Fore Street

Jeff Tarling <jst@portlandmaine.gov>
To: Jean Fraser <jf@portlandmaine.gov>

Wed, Mar 16, 2016 at 4:54 PM

**TREE PROTECTION DETAIL**  
NOT TO SCALE

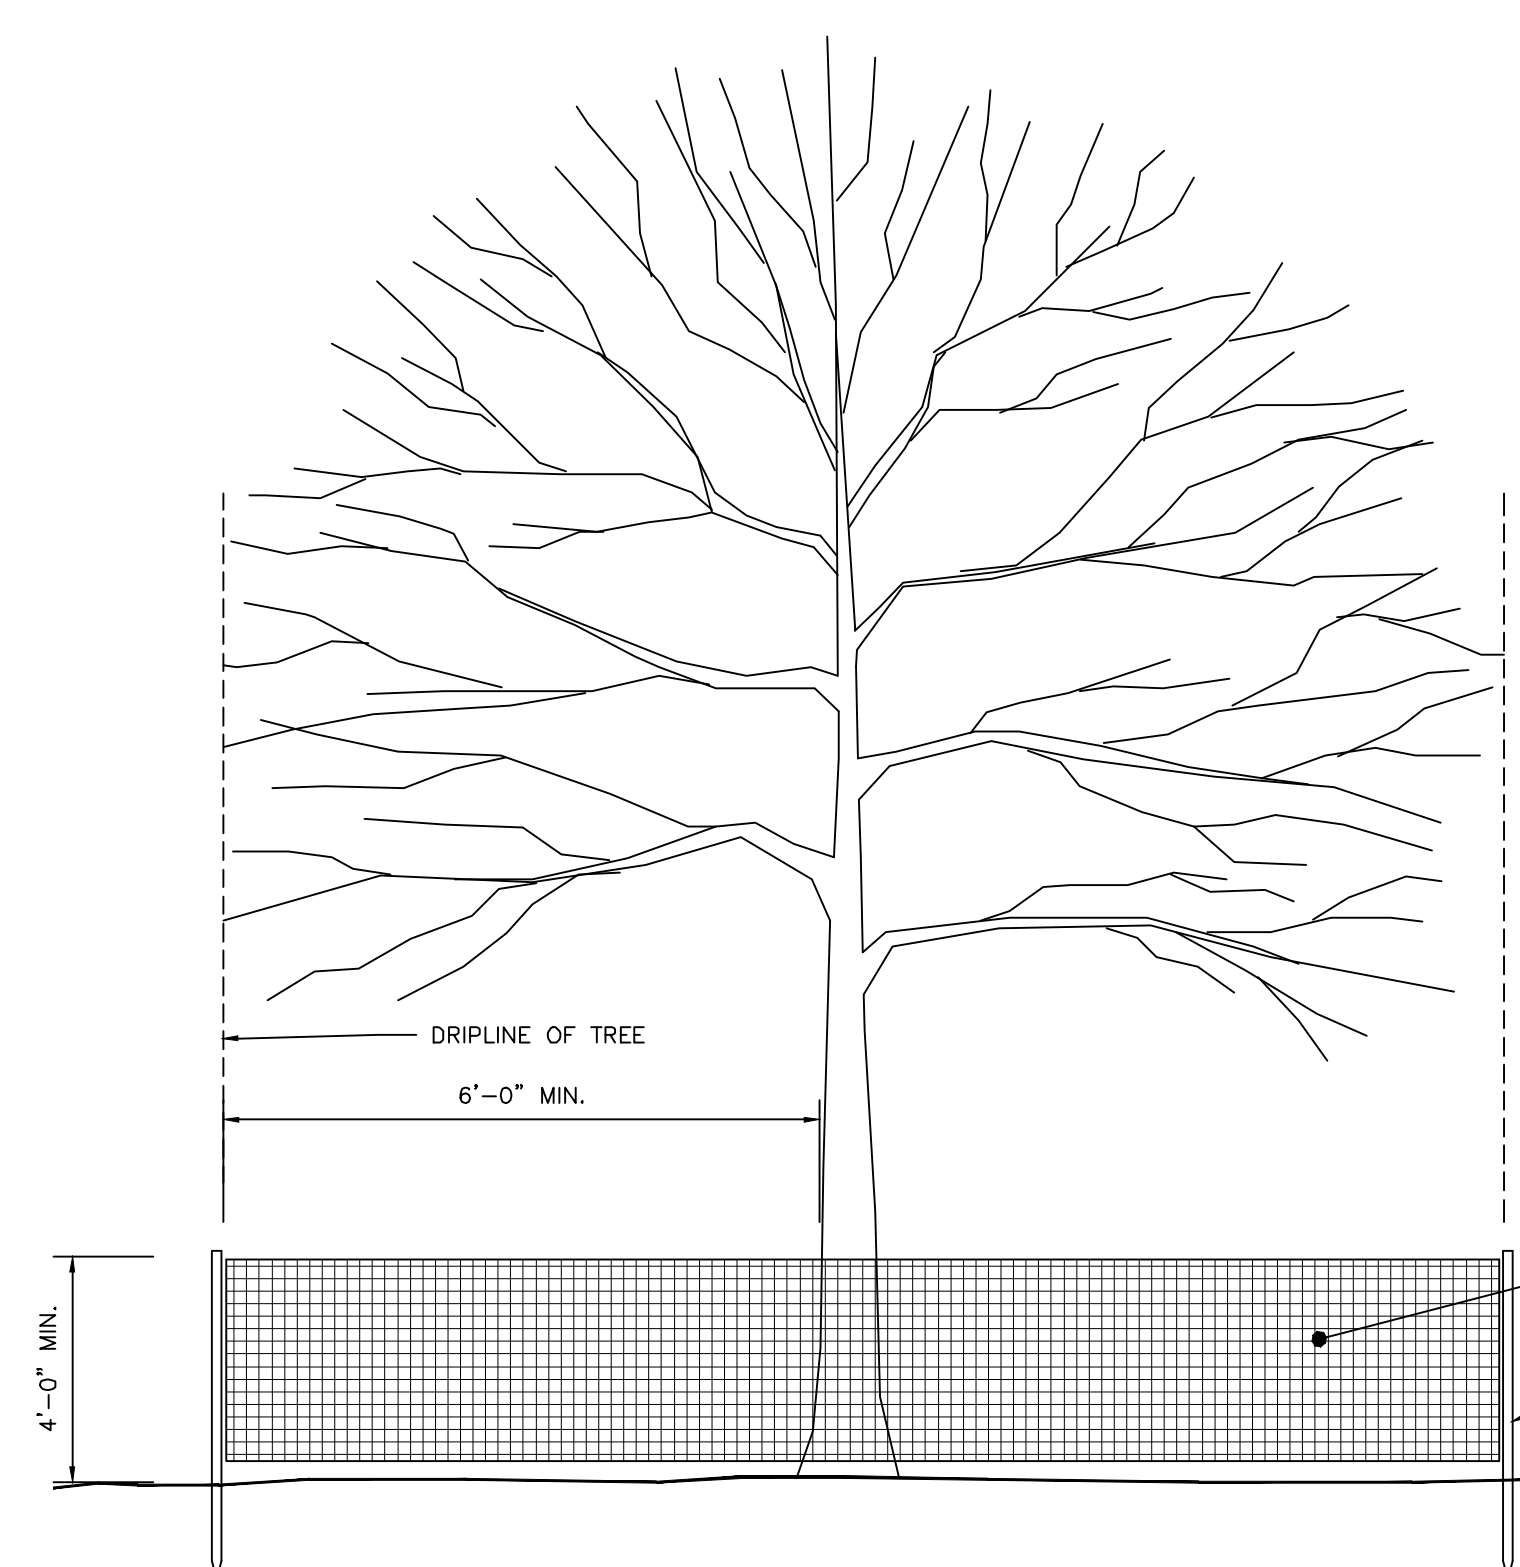
The existing Honeylocust on Fore Street which is 15' east or uphill from the fire hydrant is in good condition and will require 'tree protection' during construction. This should include trunk protection and orange construction fencing around the tree rootzone area. (Condition) The next uphill tree is about 25 feet east of the existing tree and no other space along the Fore Street frontage is open for tree planting.
